to scan
FG/42/19/HH

Ref :- FG/42/19/HH. 22, Singleton Crescent, Ferring, BN12 5DG. Single storey front extension, side extension, conversion of garage to habitable use and conversion of roof space to habitable use to include a rear dormer and 3 front roof lights.

AR-138-07

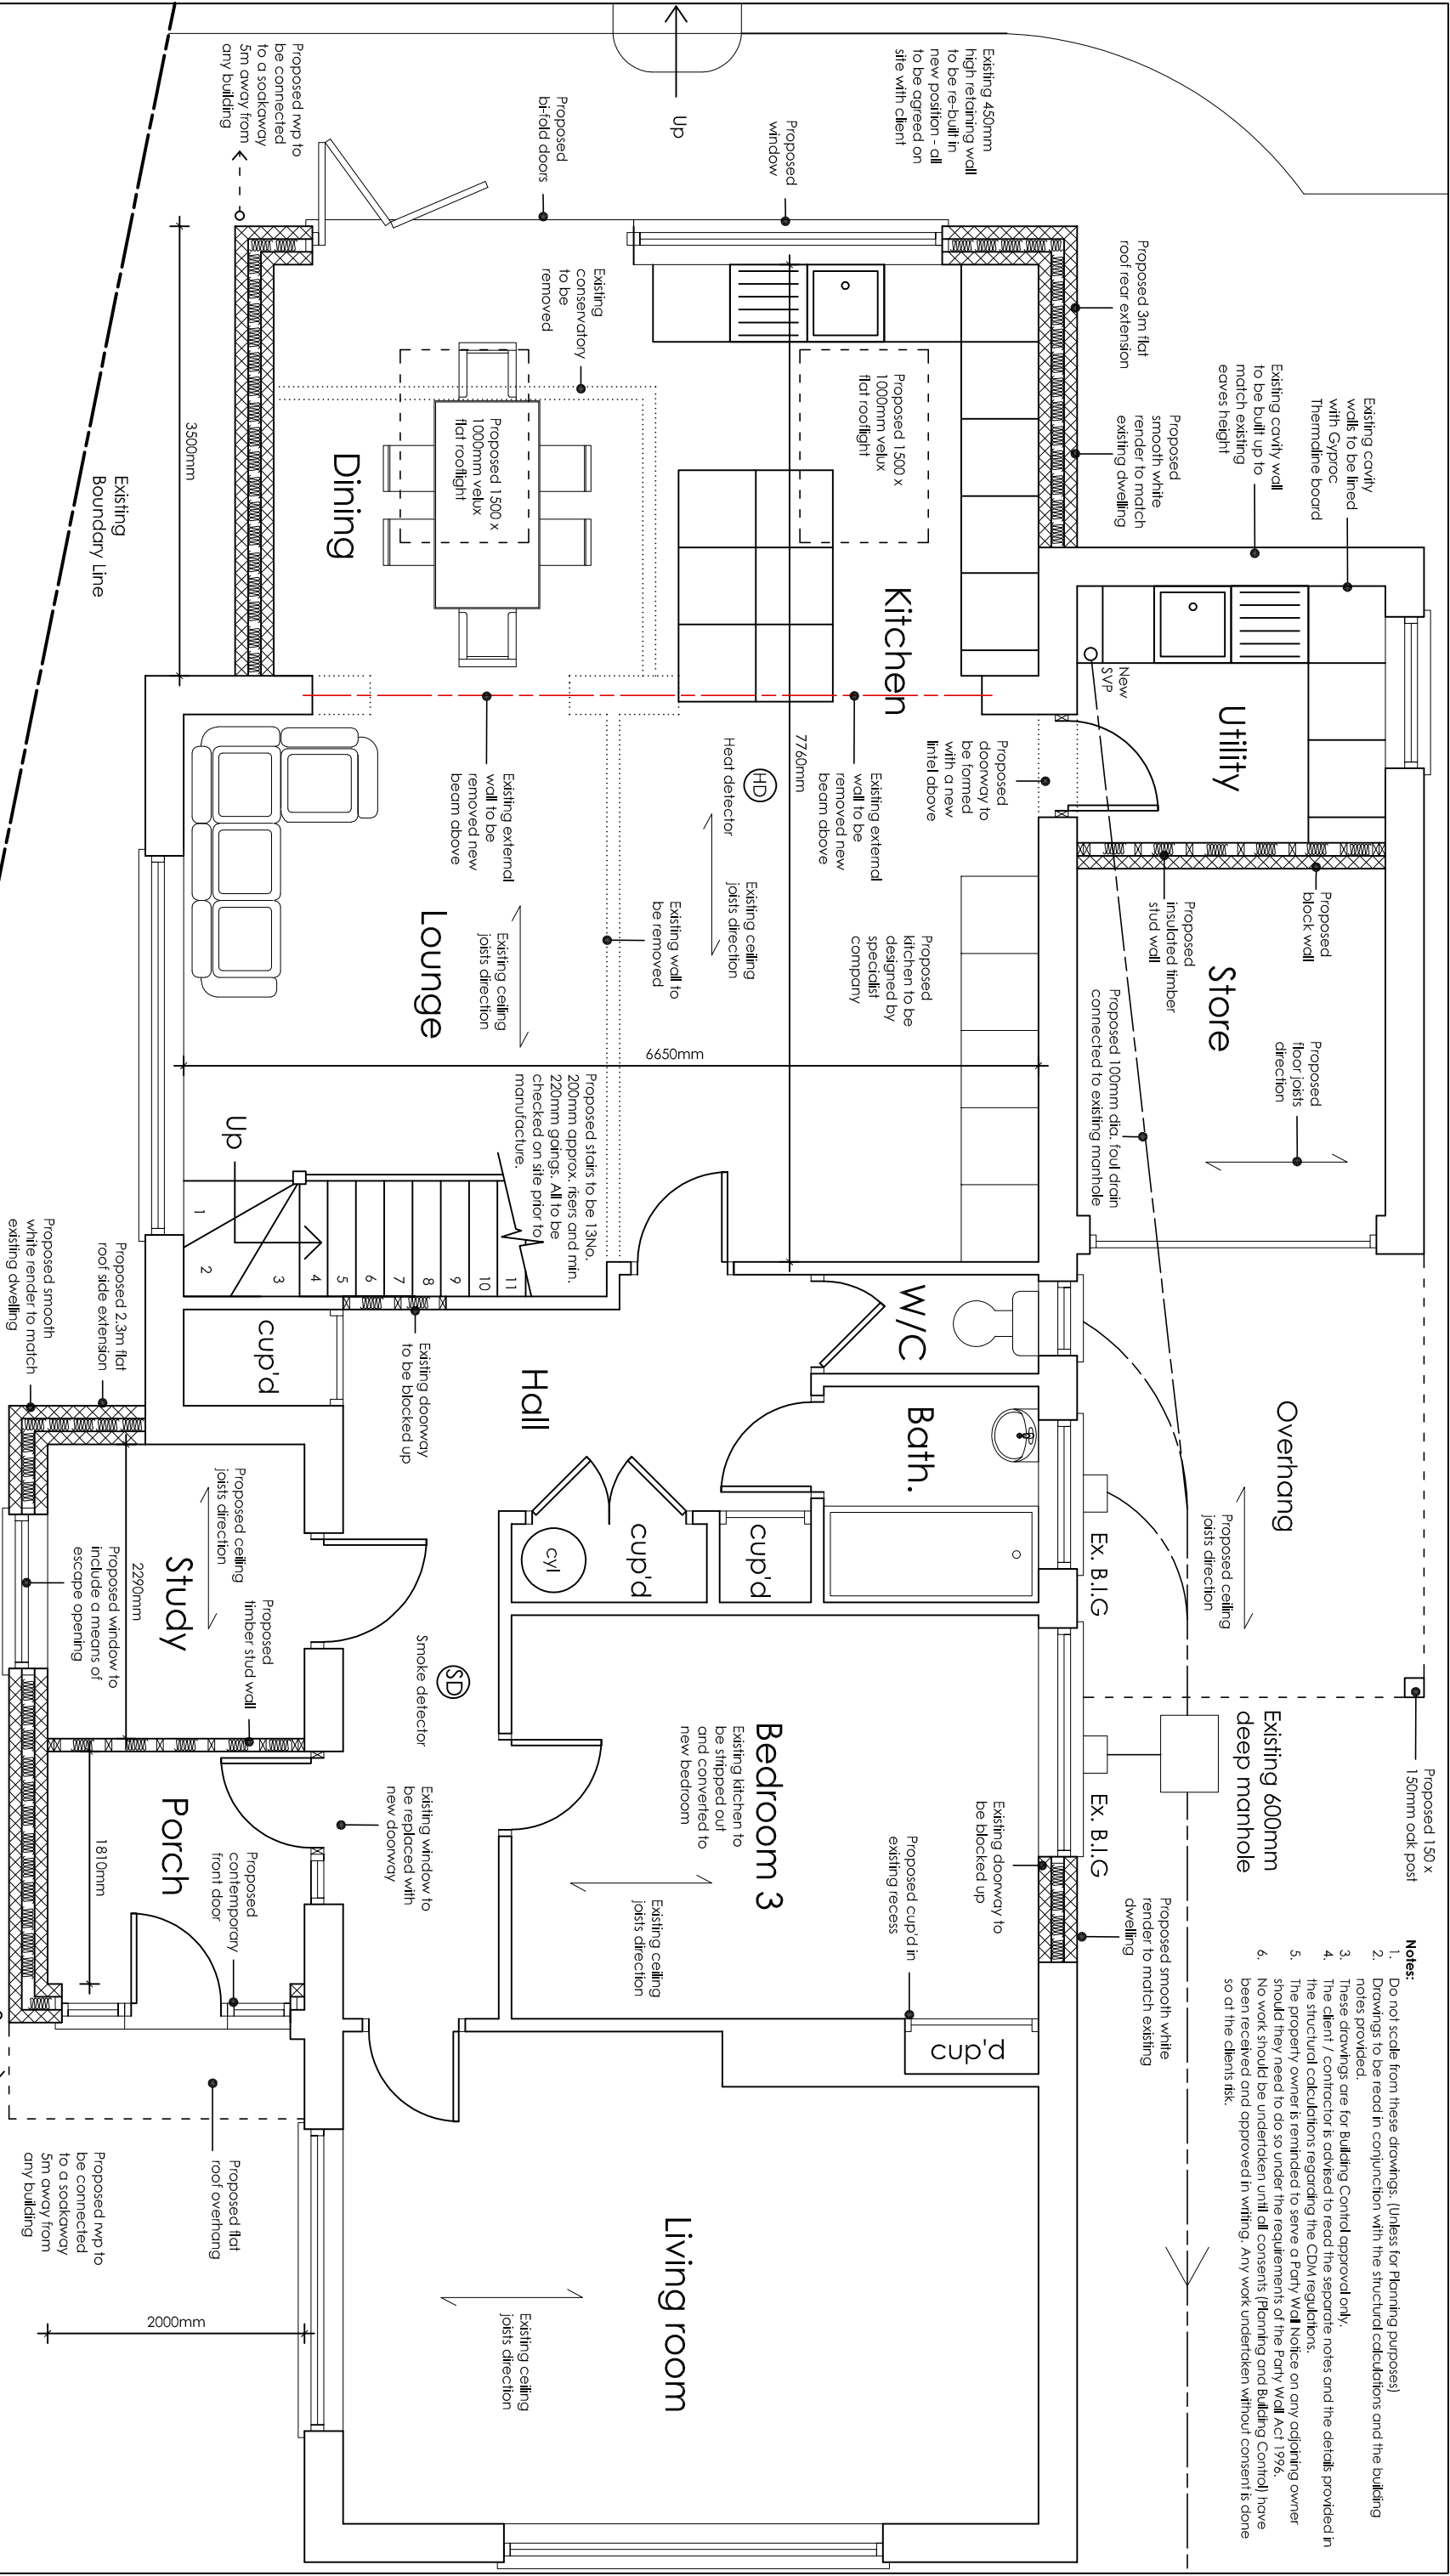
1. On diagram AR-138-07 it shows a proposed 150x150mm oak post nearby the existing 600mm deep manhole. The sewer from No. 20 enters that manhole from that direction. Is this a building control issue?
2. This site is surrounded on all sides by retired people. Can a restriction be put on development to be between 8am and 5pm Monday to Friday?

AR-138-07

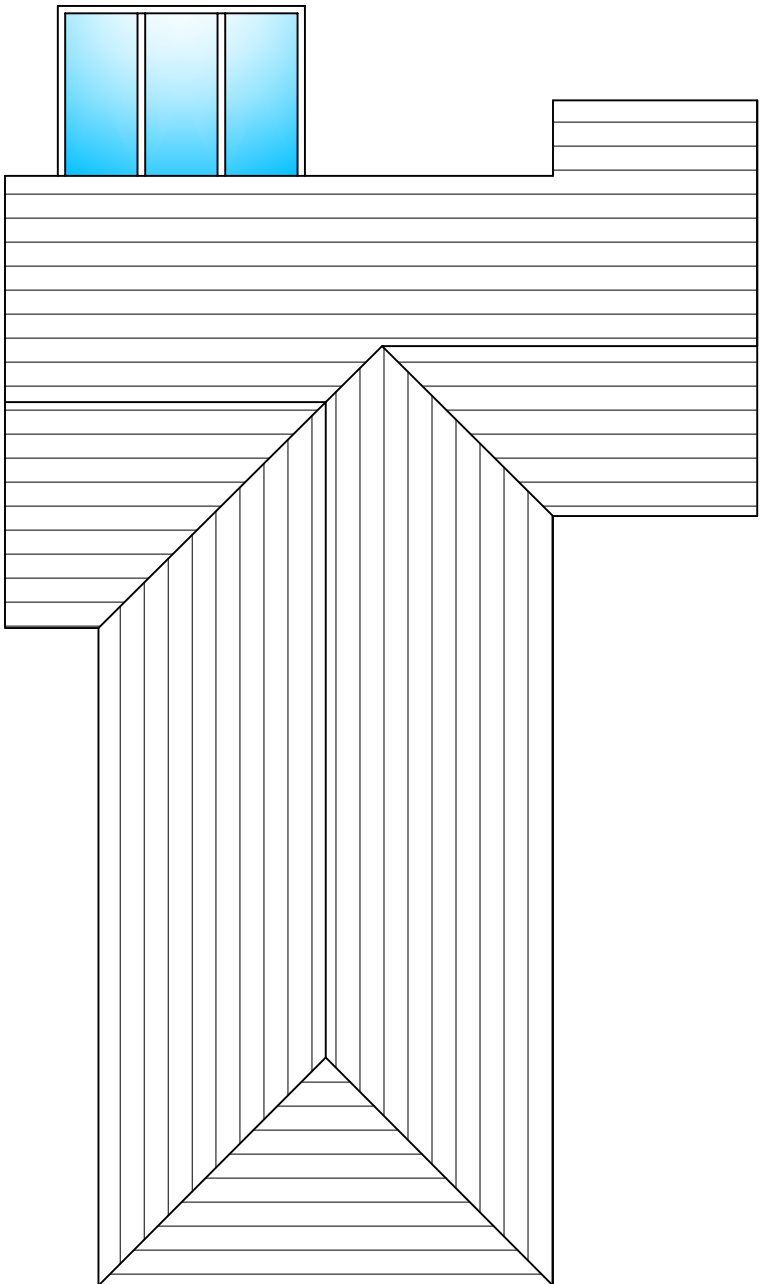
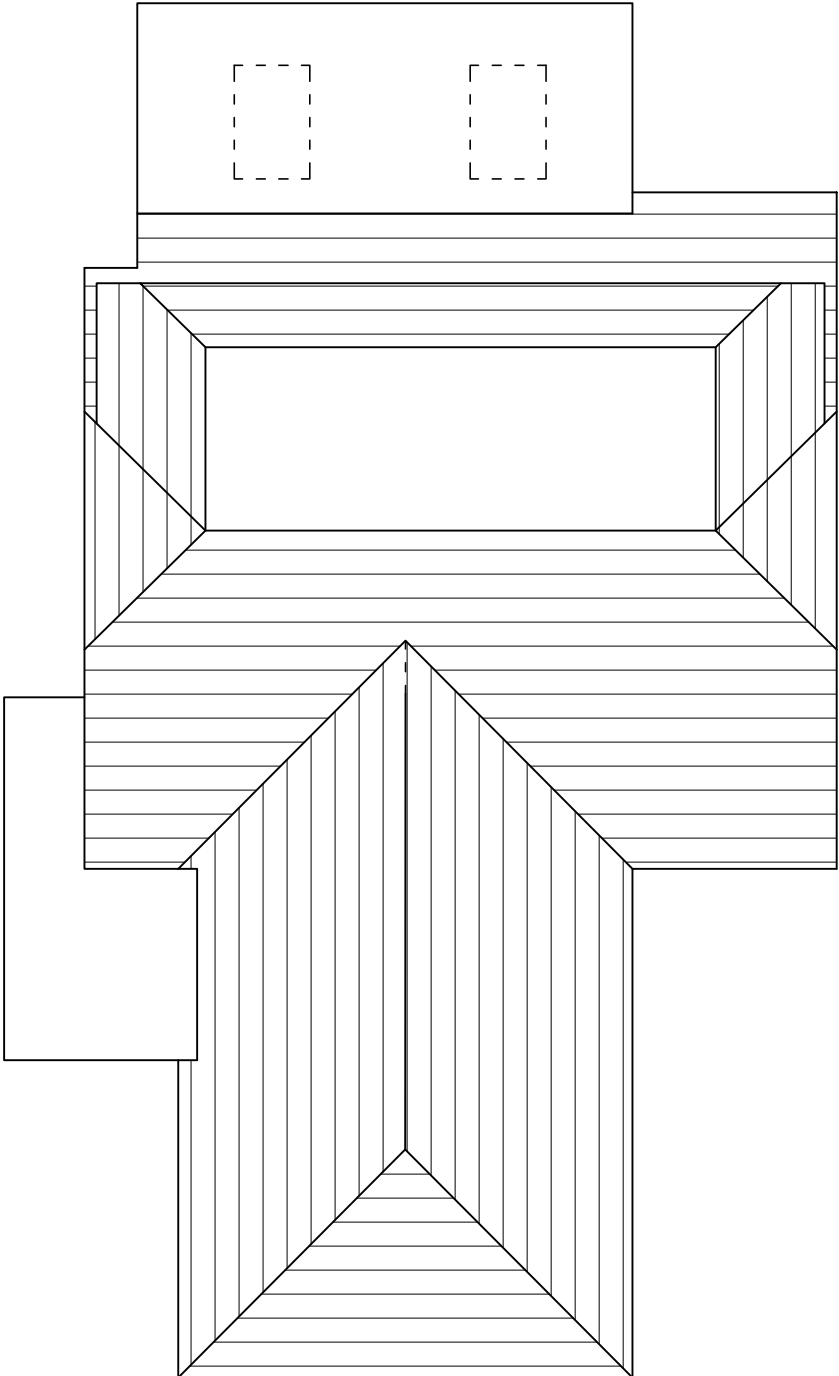
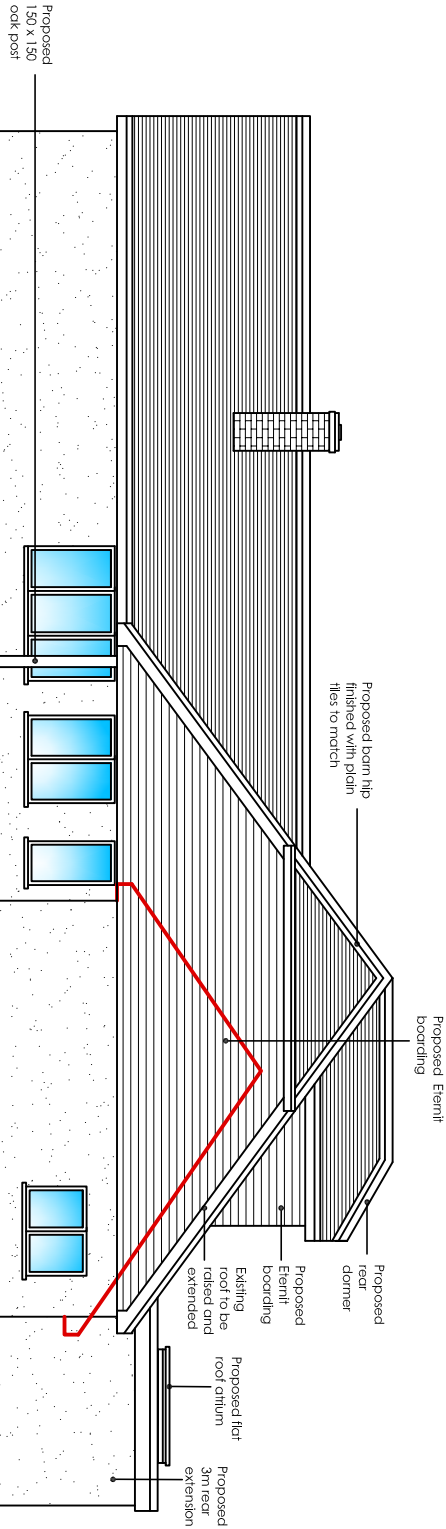
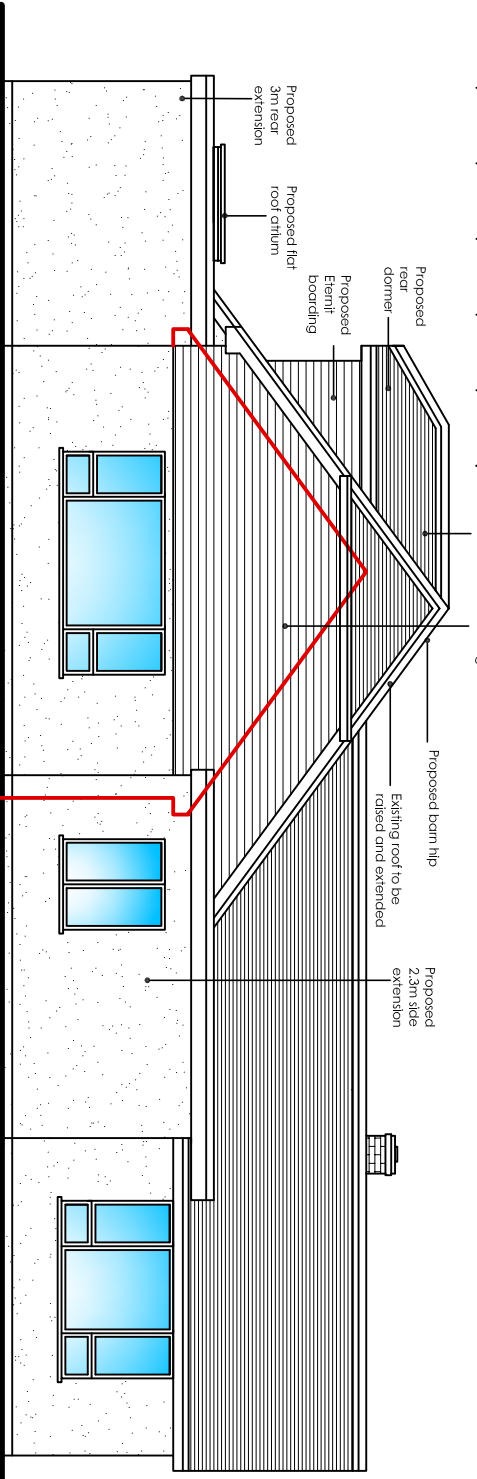
- The Architect's planning notes on the drawing No. AR-138-07 are misleading. Note 1 states that No.27 is opposite No. 22 and the street scene will be **unaffected**. This is **untrue** No. 27 is approximately **150 yards** away almost out of sight with a large weeping willow tree and 3 very large Acer trees in front of it. (**See photograph 1 attached**)

- Note 3 refers to No. 28 having had a loft extension that is the same as the proposed. This is also misleading as the loft extension was placed in the **existing** loft in a sympathetic manner as to not make any changes to the street appearance of No.28.

- The Planning descriptions and site notice only refer to 'conversion of roof space' and it is not clear to the reader without sight of the proposal plans that the application is to raise the existing roof by approx. 1 metre on the north side and 1 ½ metres on the south side and to extend it forward by approx.3 metres.

- The proposed extremely big enlargement of the roof on this small bungalow on a very small plot will have a **significant negative impact on the street scene**.

- The proposed extremely big enlargement to the roof is going to have a **significant negative effect on daylight** to the immediate neighbours especially the neighbour on the North side (No. 24).

- The Proposed Dormer windows would not have been a significant problem in the existing roof space with regard to the privacy of existing properties but in this proposed extremely big enlargement to the roof, the dormer windows will be a metre to a metre and a half higher which will have a significant detrimental effect to the privacy of the existing neighbours. This is more exaggerated to No. 20 on the south side as No. 22's roof is inclined towards that side, making the proposed dormer windows very intrusive at the proposed height.
